STATE OF NORTH CAROLINA
DEPARTMENT OF TRANSPORTATION

Addendum No. 1

RE: Contract # C204329

I-73/74 FROM SR-1455 TO US-220 IN RICHMOND COUNTY AND
FROM NC-211 TO NC-24/27 IN MONTGOMERY COUNTY.

MAPS 1 THRU 22 ARE OMITTED.

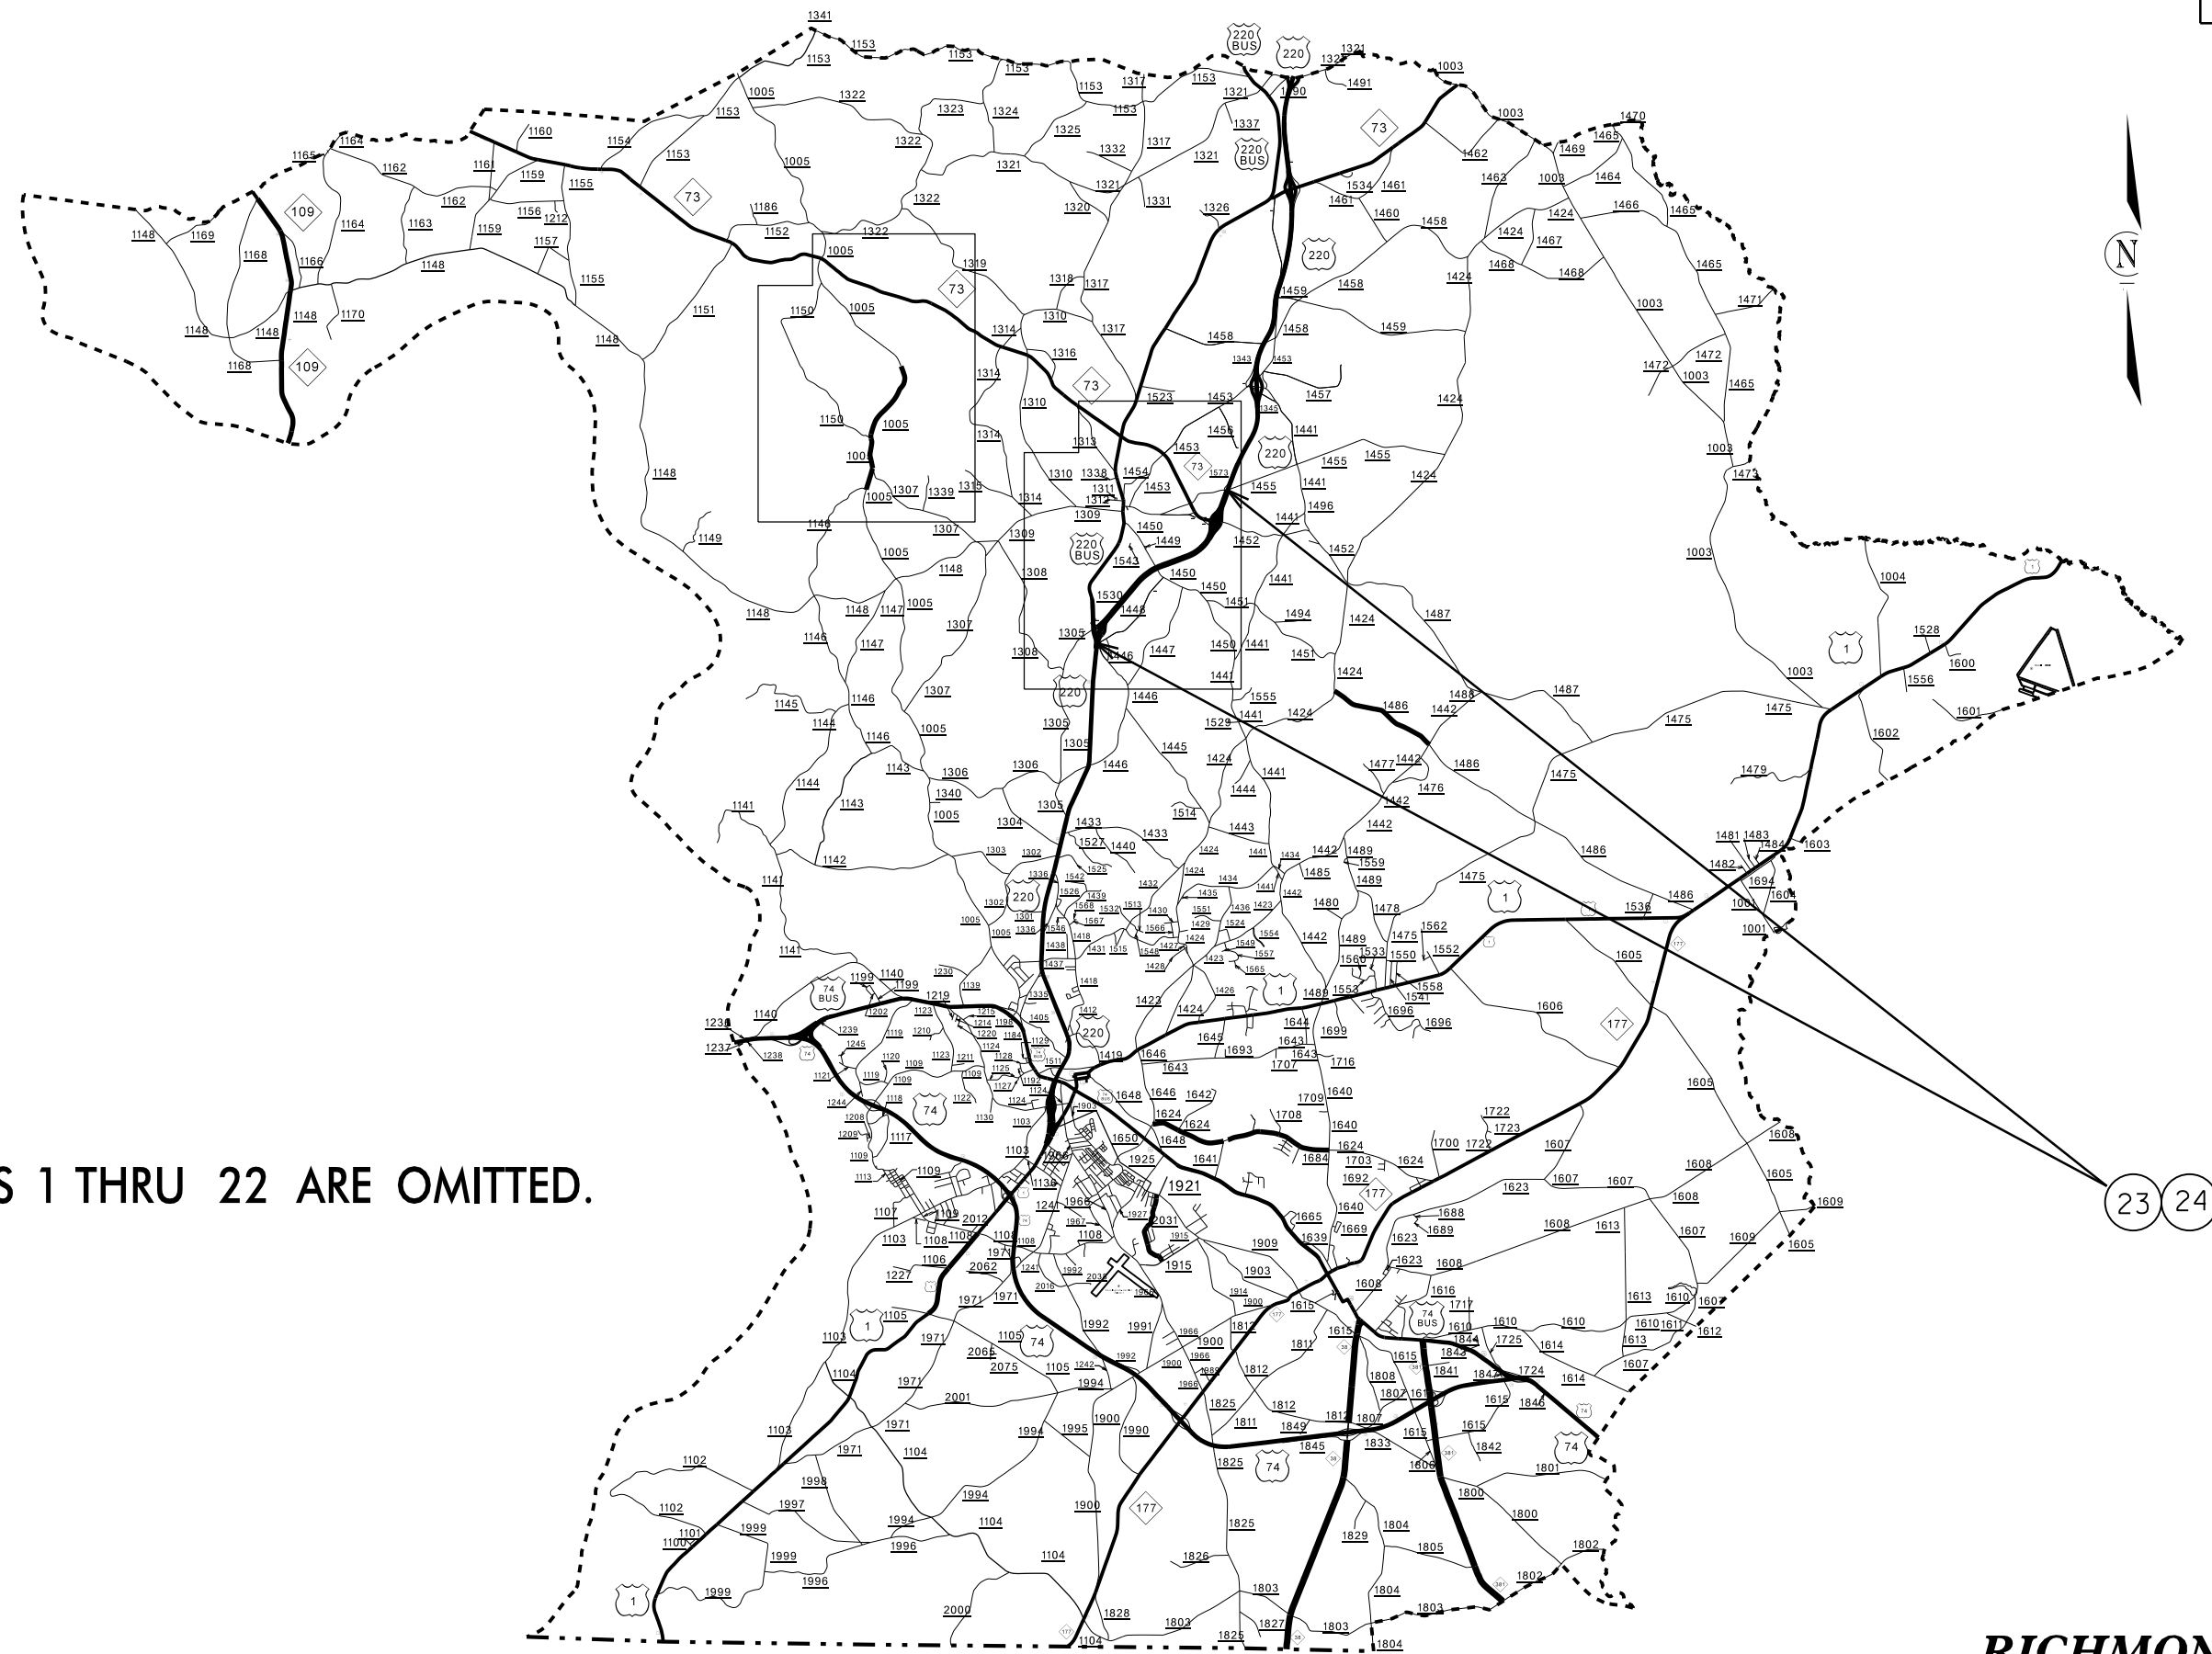
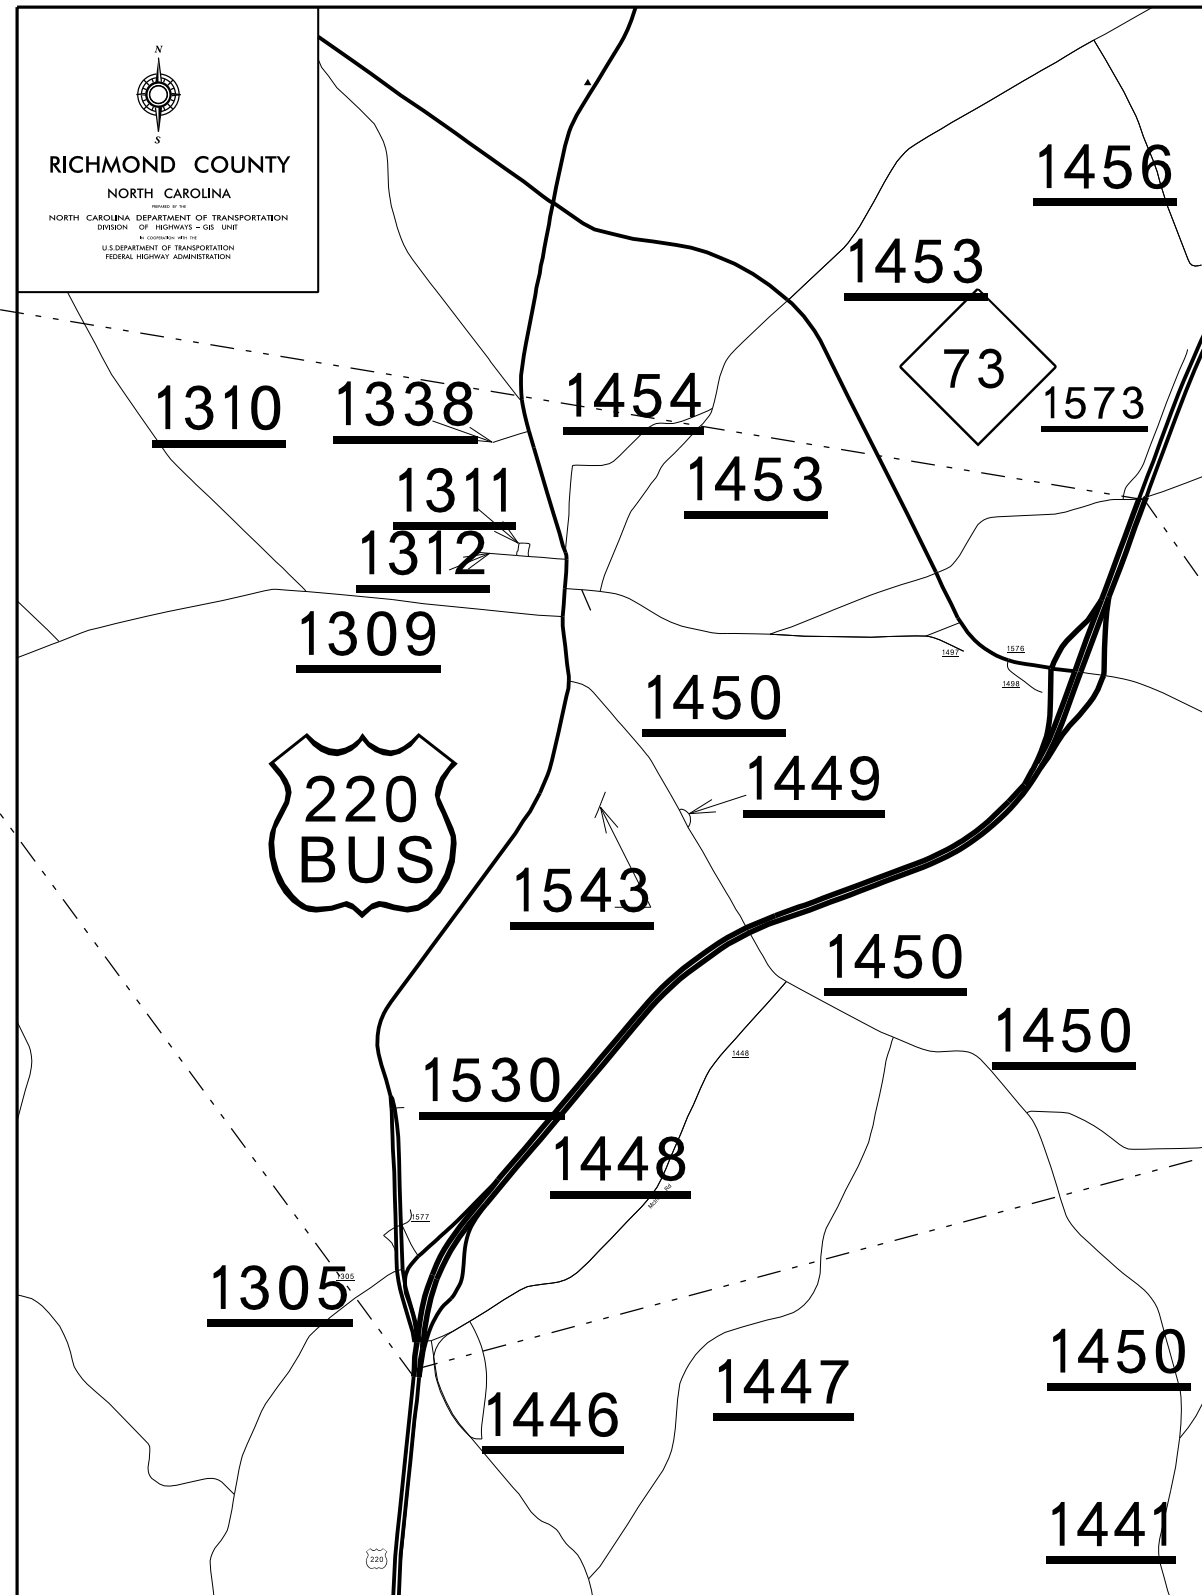
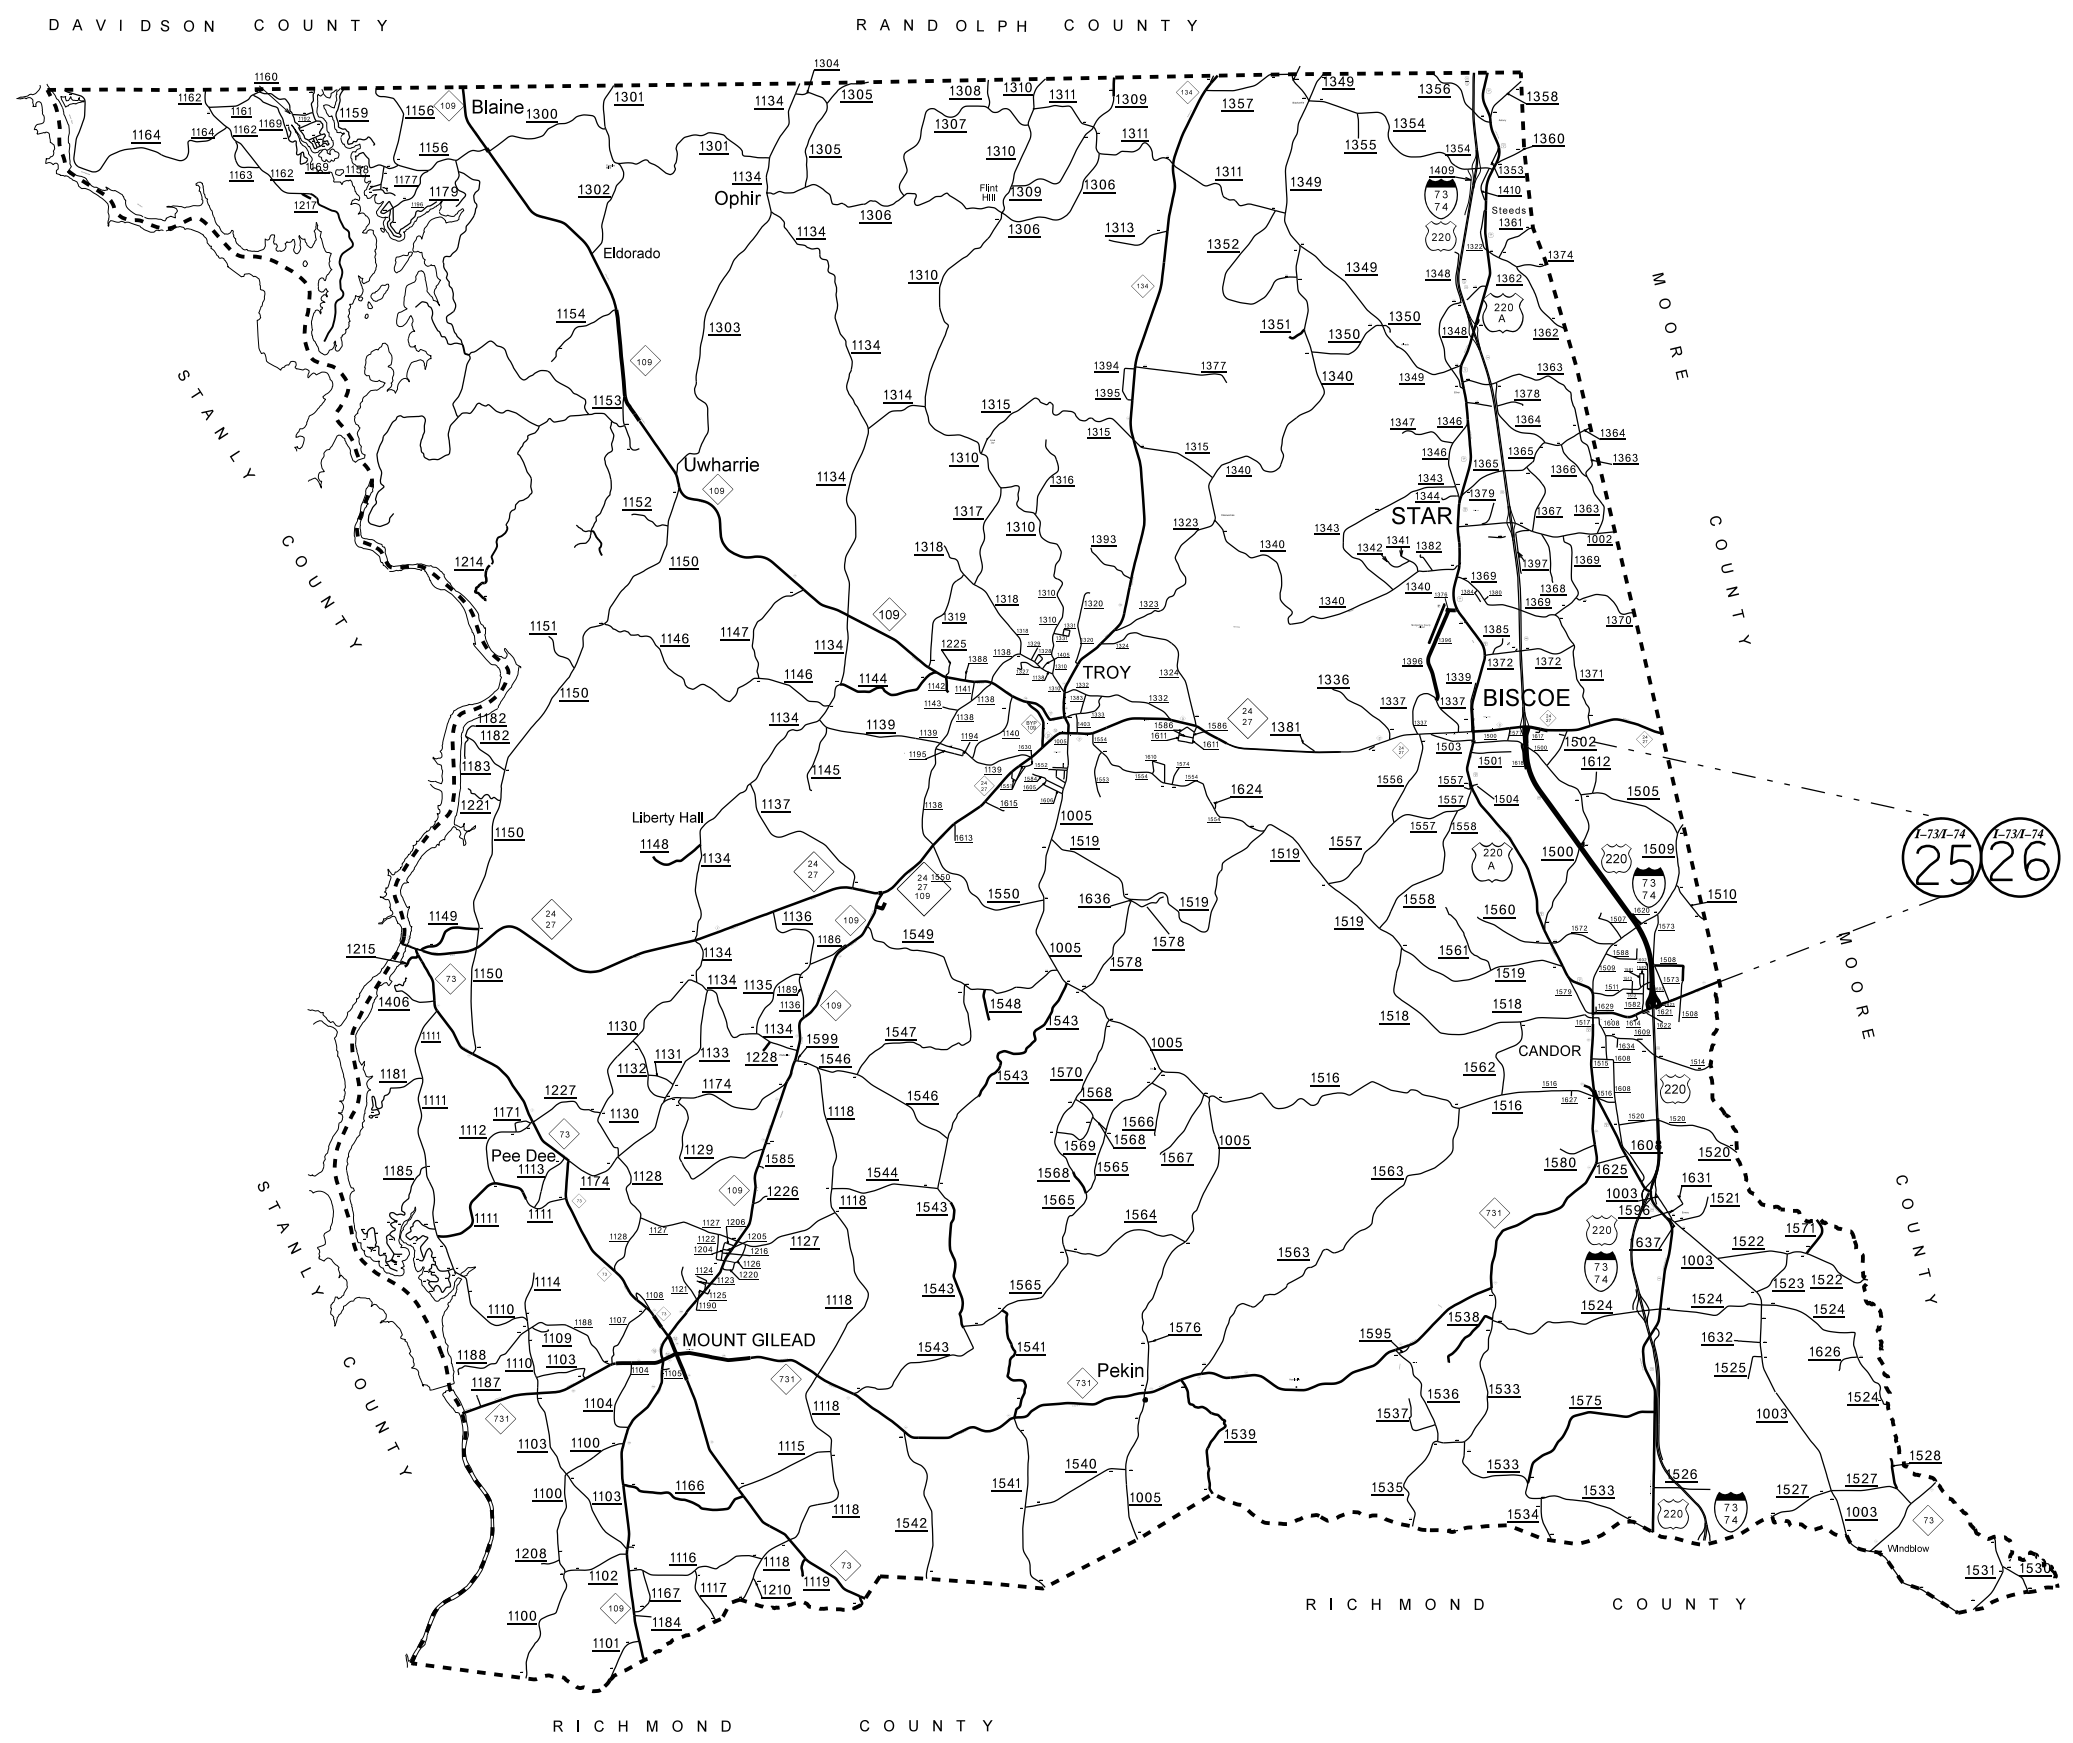
Sheet No.	Revisions
All Sheets	Project Numbers/WBS Numbers have been revised/deleted. Maps 1 thru 22 have been deleted from this project.

Please discard all previous sheets and refer to new Sheets 1 thru TMP-1.
